**CITY OF ALBUQUERQUE
PLANNING DEPARTMENT
November 17, 2010
DRB Comments**

PROJECT # 1004532 APPLICATION # 10-70318

RE: Tract B-1, Mesa del Norte Addition

TRACT B-1-A & TRACT B-1-B, MESA DEL NORTE SUBDIVISION

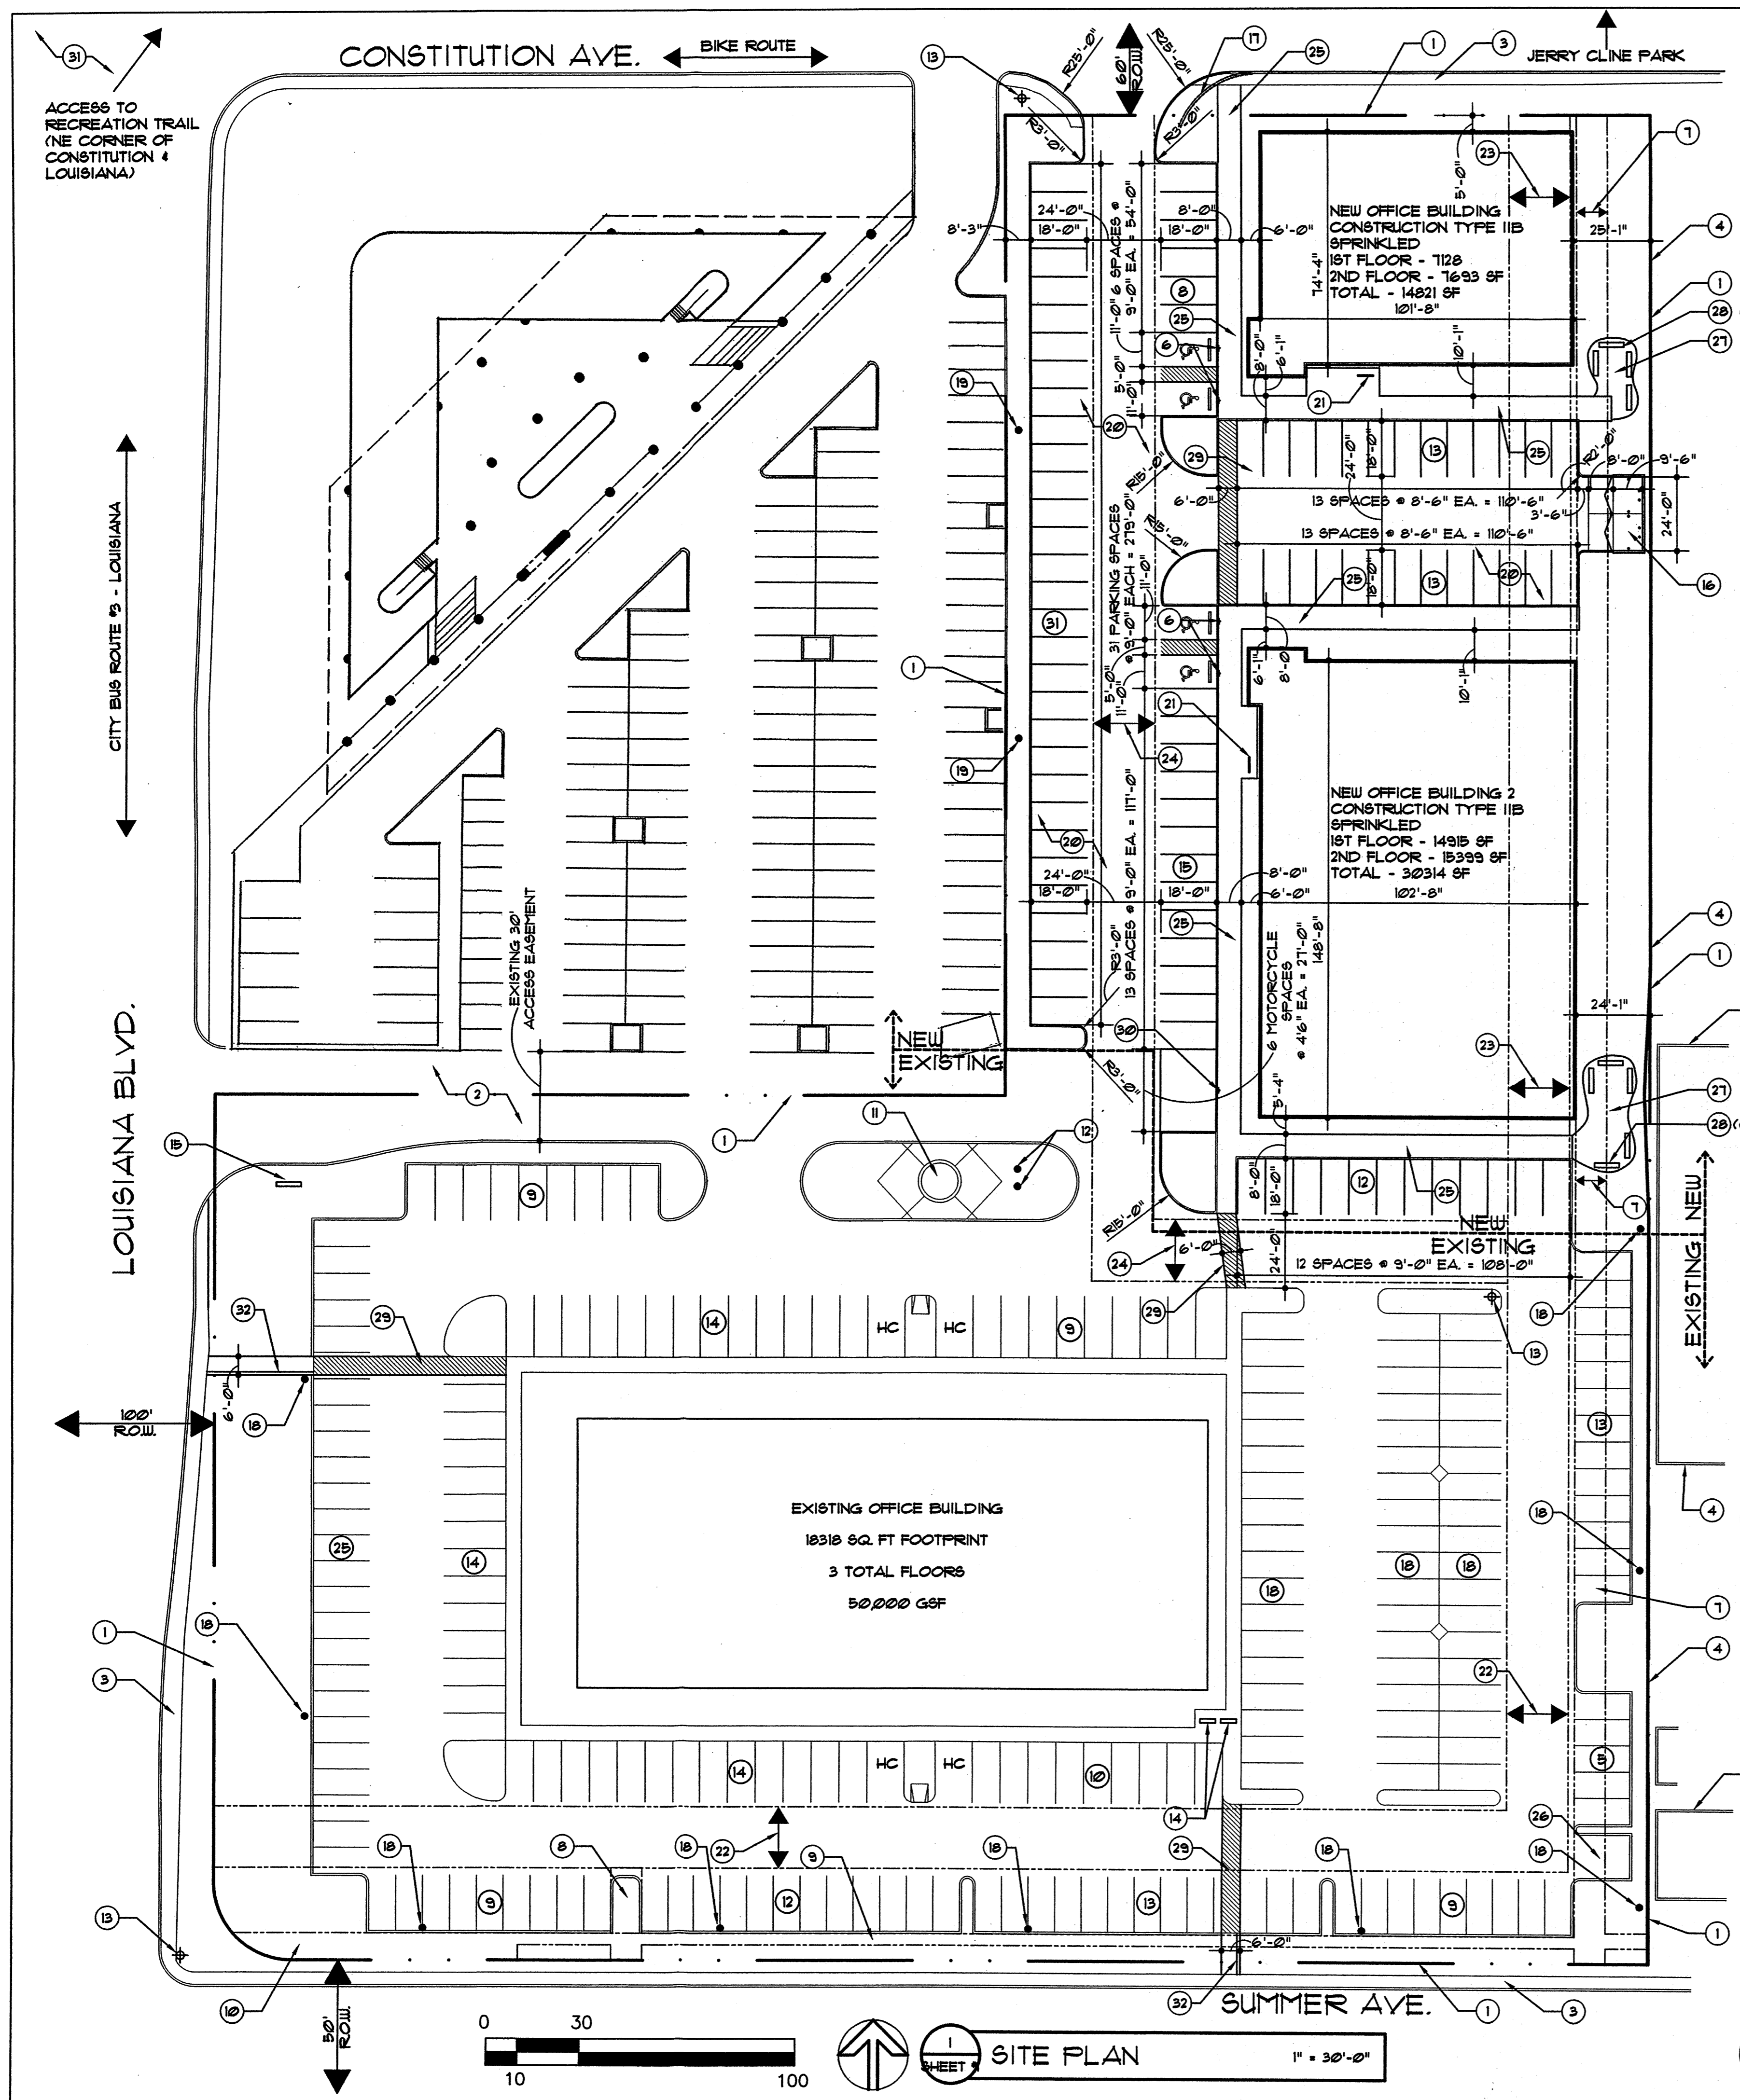
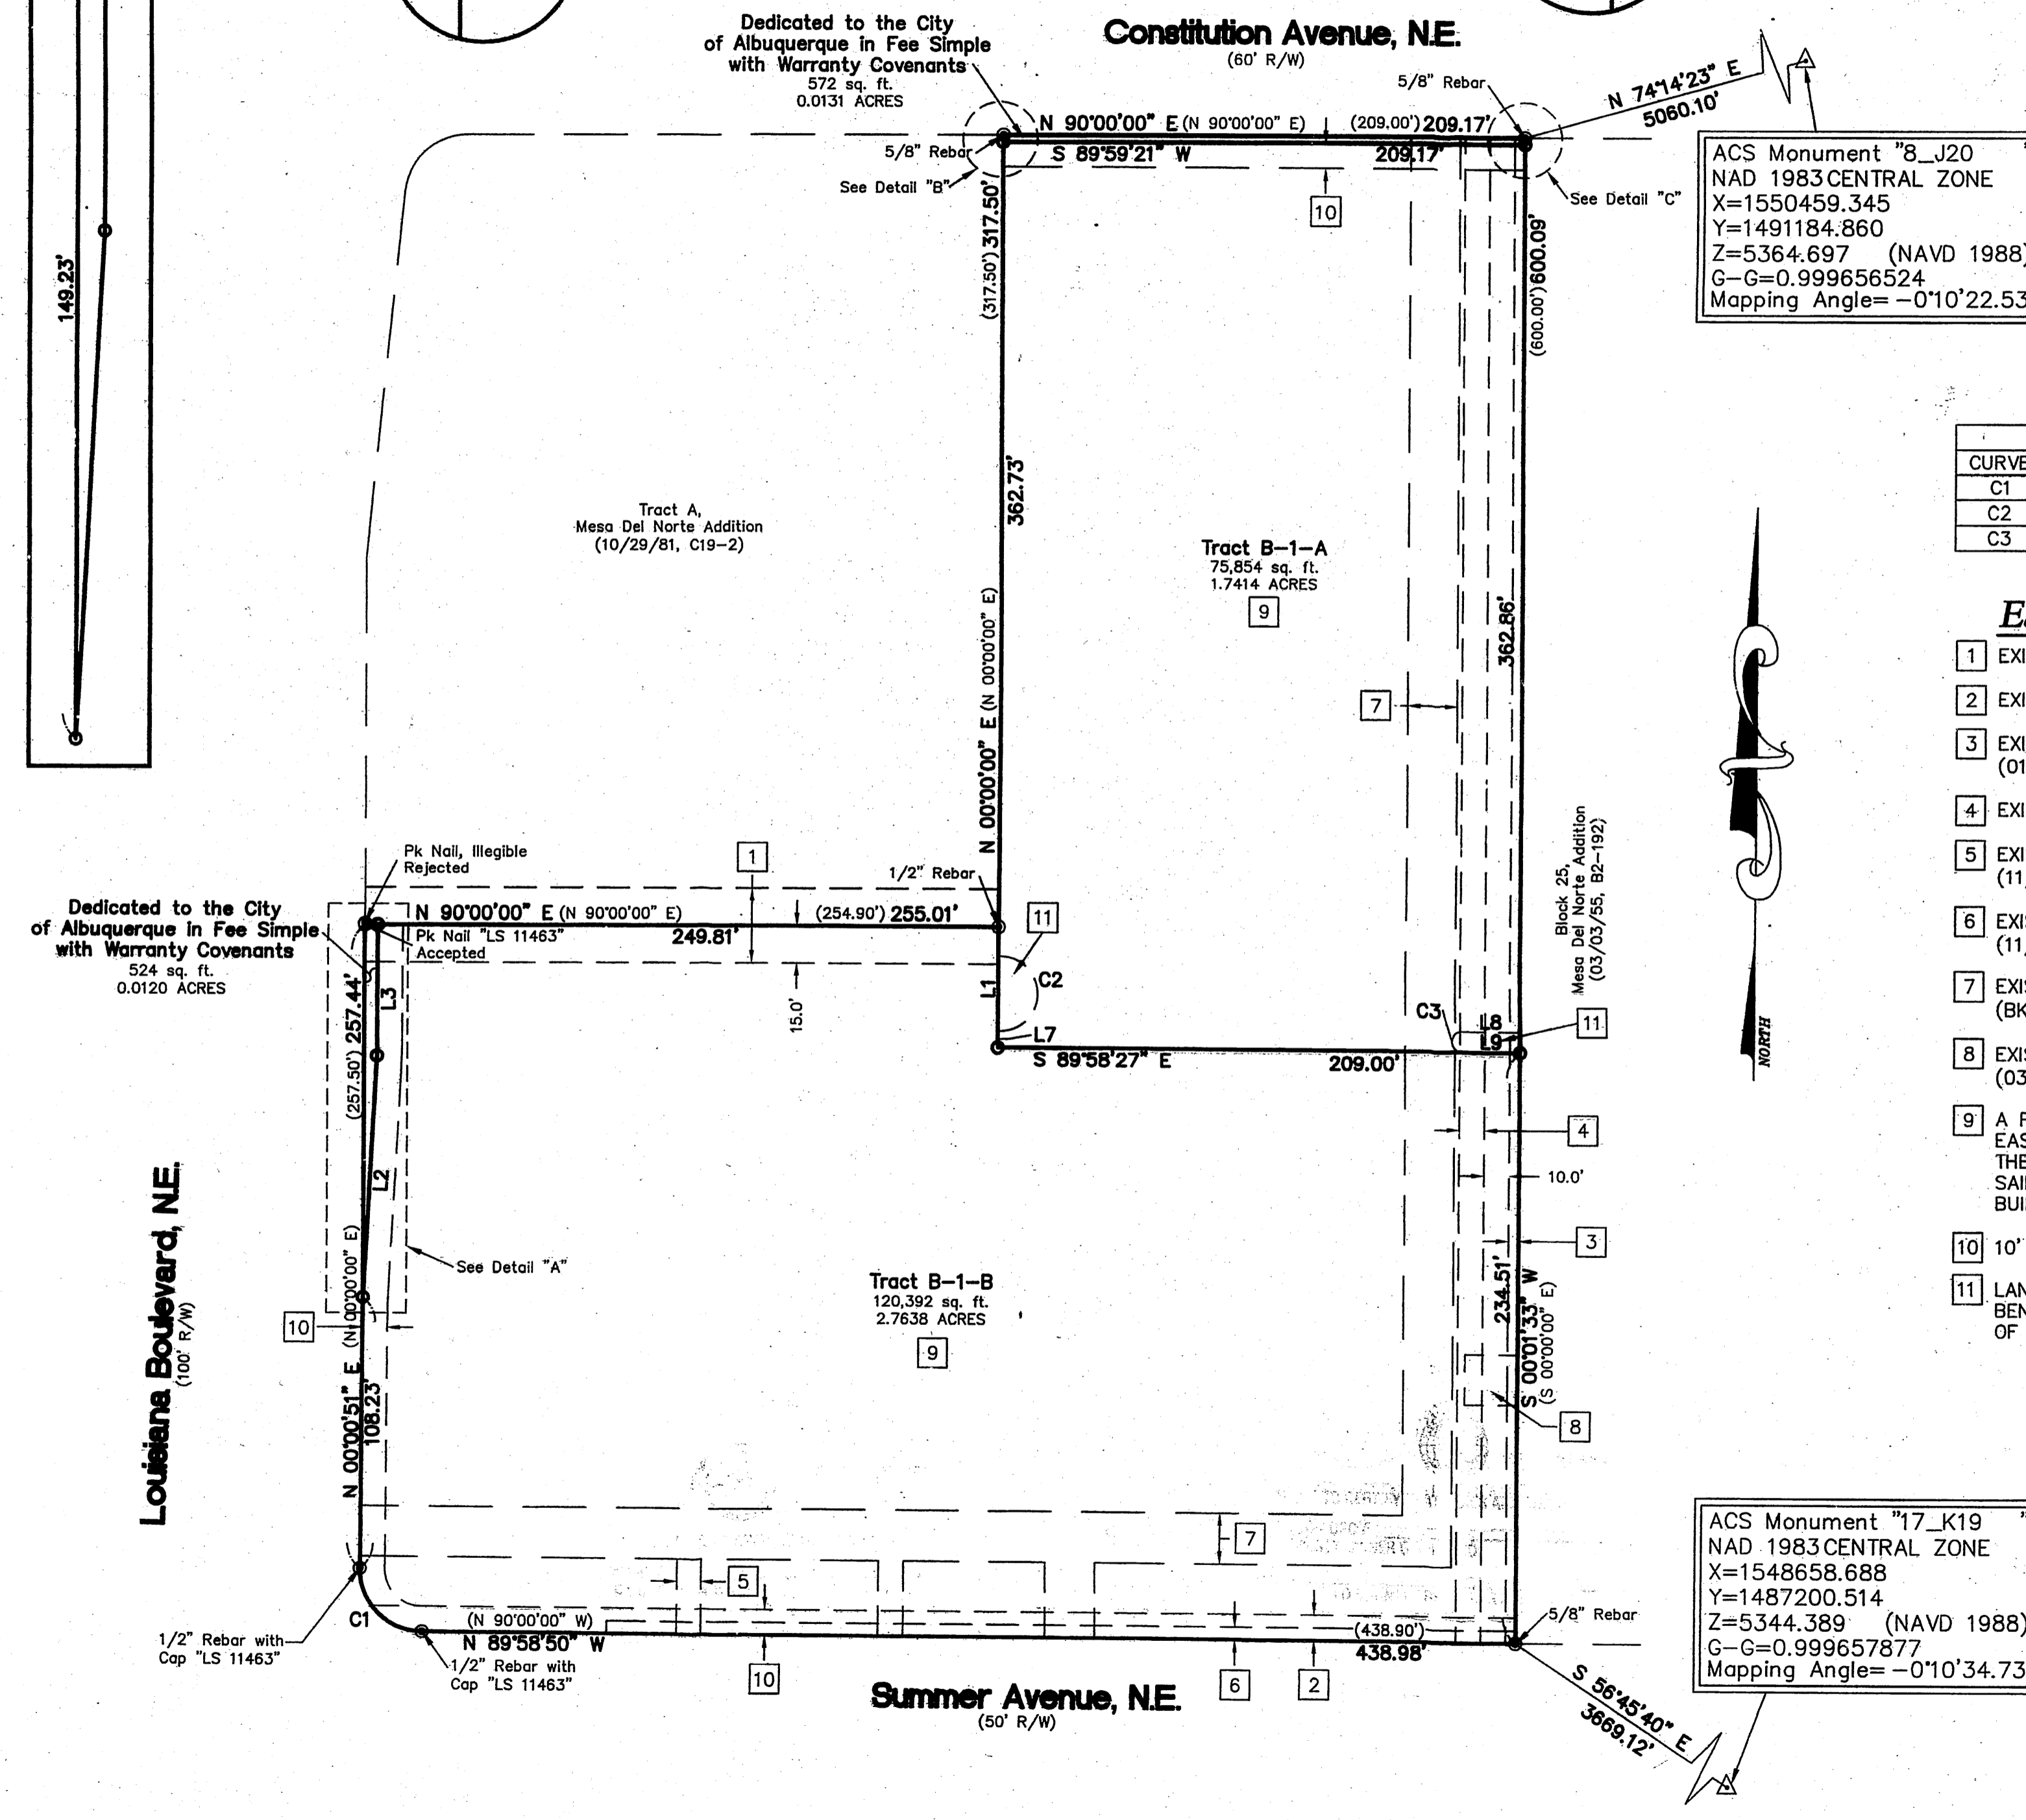
Per § 14-14-2-2 of the Subdivision Ordinance, platting must conform to an approved site plan. There was a relatively recent site plan with this project number that was approved by EPC but evidently has not been signed-off by DRB. That site plan should be finalized if this proposed plat would conform. If a different layout is needed for this subdivision, that site plan should be withdrawn and the previous site plan (Z-88-9?) should be reviewed; if this subdivision does not conform with the previous site plan, perhaps it could be administratively amended.

If there is no significant infrastructure required, this would be a minor subdivision.

Proposed Easement Note 9 needs to include Tract A as a beneficiary. A landscape easement is needed for existing landscape improvements.
